WEST SUSSEX COUNTY COUNCIL CONSULTATION

TO:	Arun District Council FAO: Mrs A Gardner
FROM:	Highways, WSCC
DATE:	07/12/2018
LOCATION:	Land to the north of, 68, Arundel Road, Angmering, Littlehampton, BN16 4LL
SUBJECT:	A/161/18/RES Approval of reserved matters following outline consent A/31/18/OUT for 2 No dwellings.
DATE OF SITE VISIT:	N/A
RECOMMENDATION:	☒ Advice ☐ Objection ☐ Modification ☐ No Objection ☐ More Information ☐ Refusal
S106 CONTRIBUTION TOTAL:	£N/A

TITLE:
PROPOSED SITE PLAN

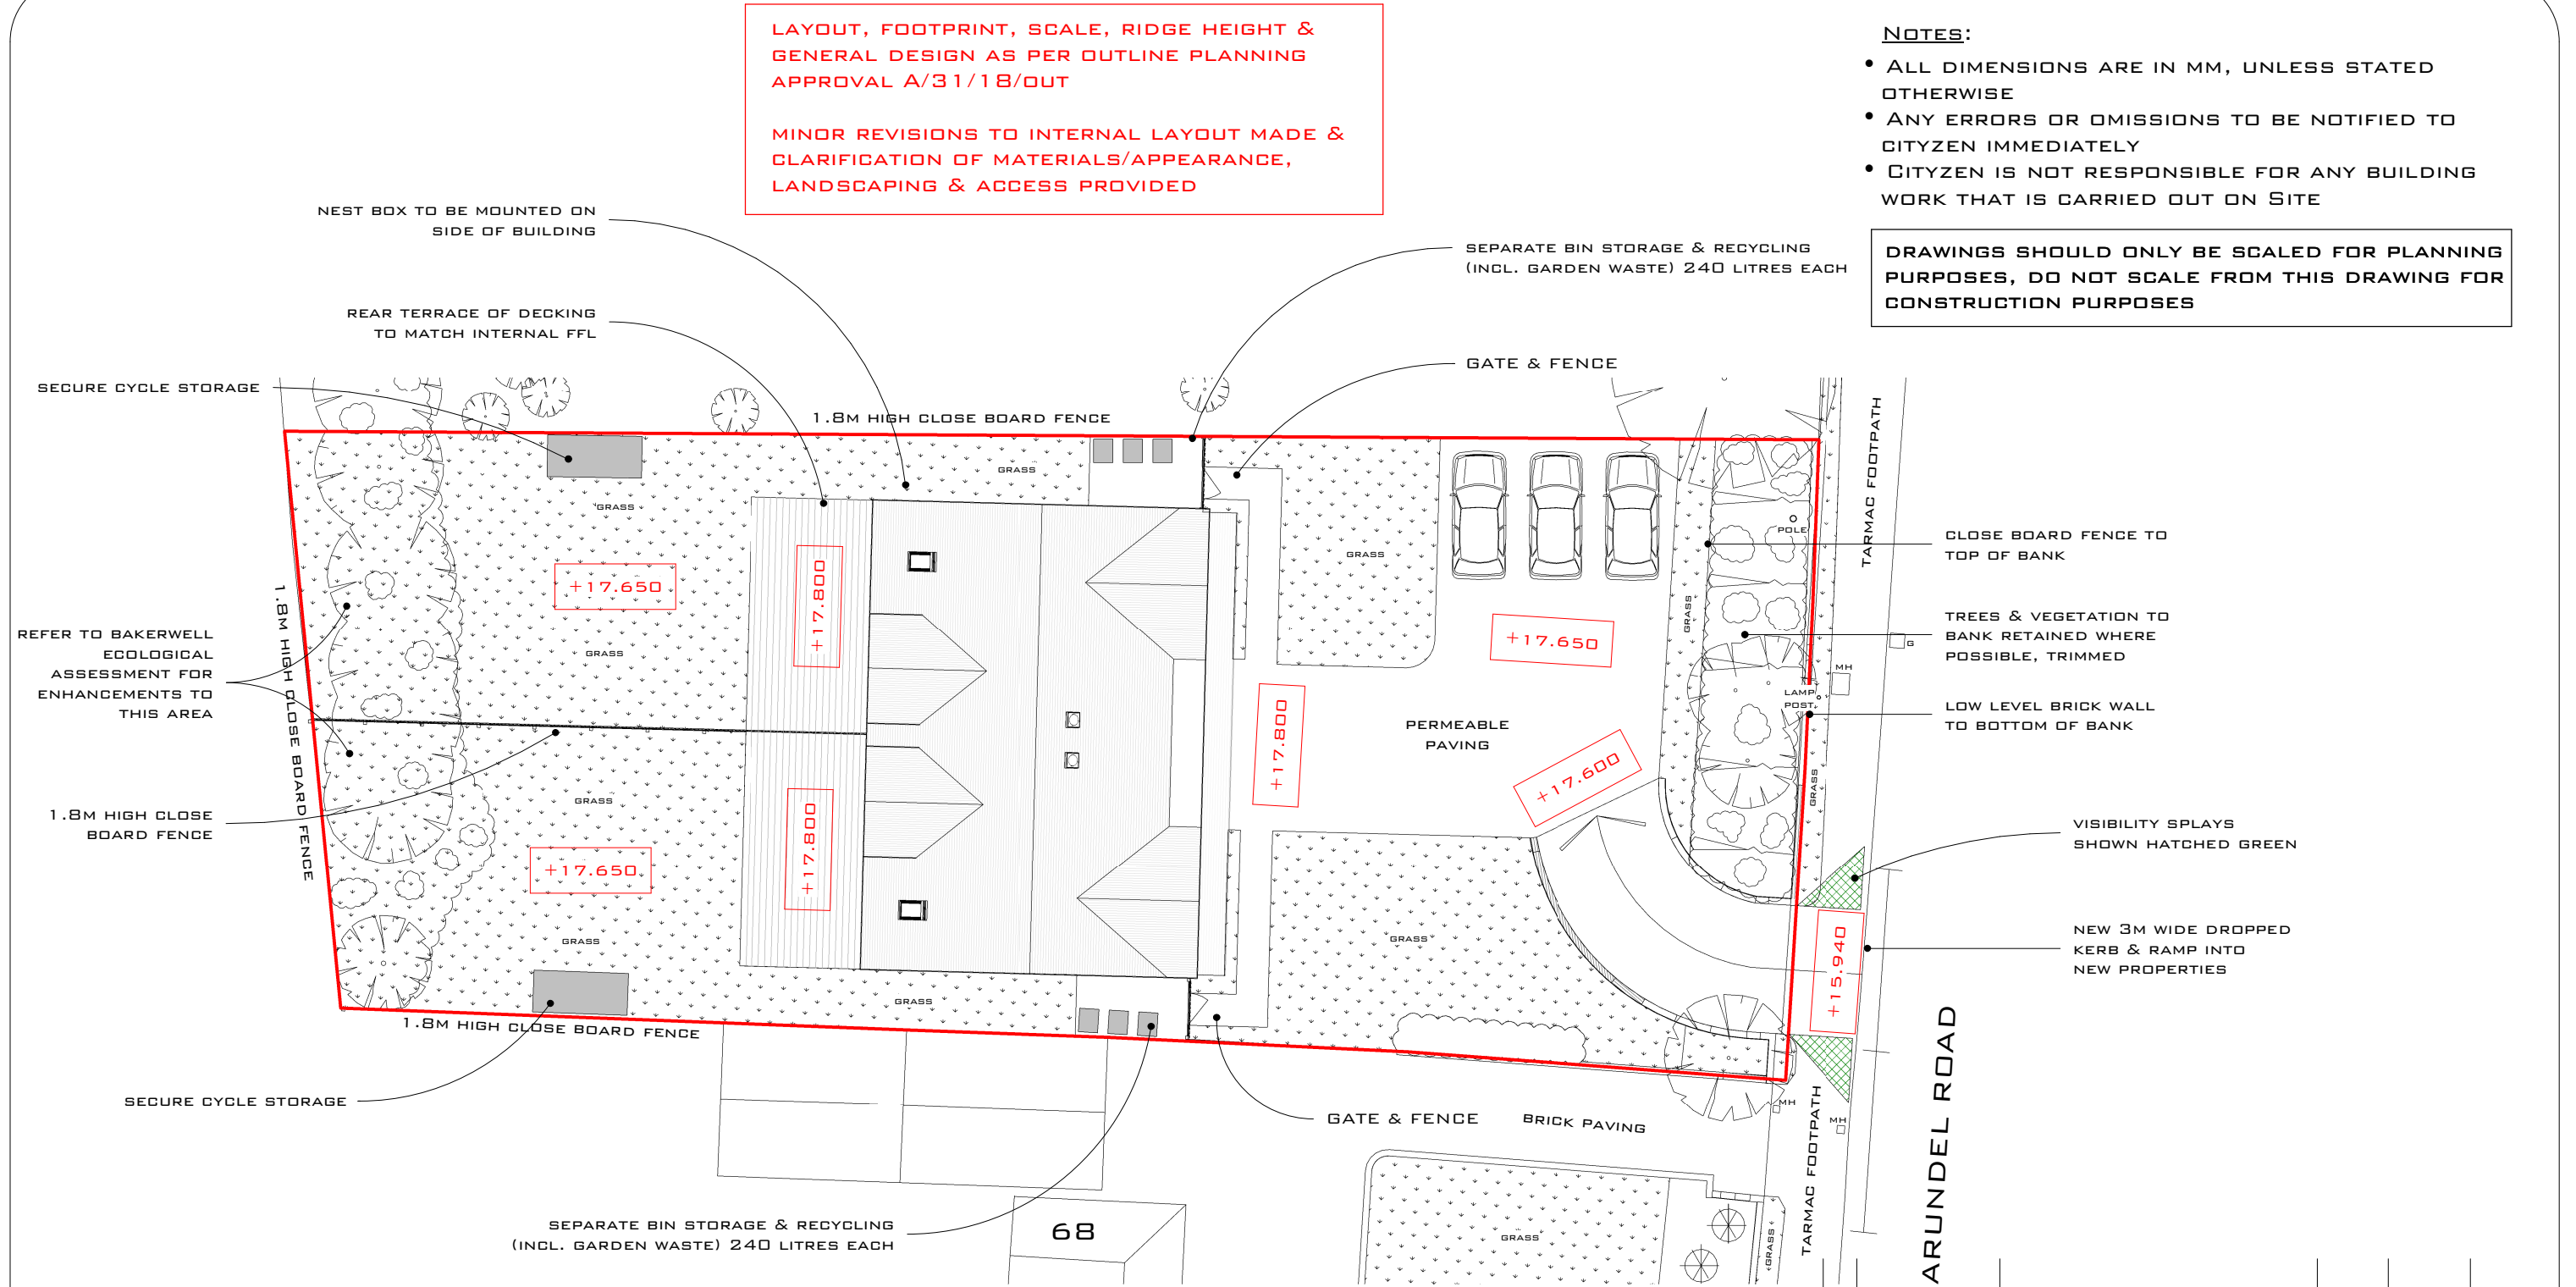
The plans submitted indicate that a new 3m wide shared access is proposed onto Arundel Road. However, this appears to scale off at 4m. As advised at Outline stage, the proposed access will require a licence and construction to a specification agreed with the Local Highways Engineer. The LHA also advised that considering the access is to be shared between two dwellings the access should be widened to 4.5m to allow two cars to pass.

Pedestrian visibility has been demonstrated, however these splays should be provided within the applicants own land, not within publically maintained highway. Provision of these splays would require that the proposed access be relocated slightly north. Pedestrian visibility splays should be taken 2m back into the access and a distance measured along the back of the footway for 2m on each side of the access. Boundary treatments should be maintained to a maximum height of 0.6m within these splays. Details of the widened access and pedestrian splays can be secured by condition.

The proposed plans demonstrate a reduction in parking provision for the site than that demonstrated at Outline stage. A total of three parking spaces will be provided for the development. It has not been clarified whether these spaces will be allocated or unallocated. Based upon the three spaces remaining unallocated, the WSCC parking demand calculator expects that this is sufficient parking provision for a development of this size and location. If the applicant intends to allocate parking spaces, a minimum of four spaces will be required. The LPA may wish to consider the potential impacts of any overspill parking from this development on on-street parking from an amenity point of view. Each space meets minimum dimensions of 2.4 x 4.8m as set out in MfS. A turn on site has not been demonstrated but appears achievable in this location.

No part of the development shall be first occupied until pedestrian visibility splays of 2 metres by 2 metres have been provided either side of the proposed site vehicular access onto Arundel Road in accordance with plans and details to be submitted to and approved in writing by the Local Planning Authority. These visibility splays shall thereafter be kept free of all obstructions over a height of 0.6 metre above adjoining carriageway level or as otherwise agreed.

No part of the development shall be first occupied until the vehicle parking and turning spaces have been constructed in accordance with the approved plan. These spaces shall thereafter be retained for their designated use.
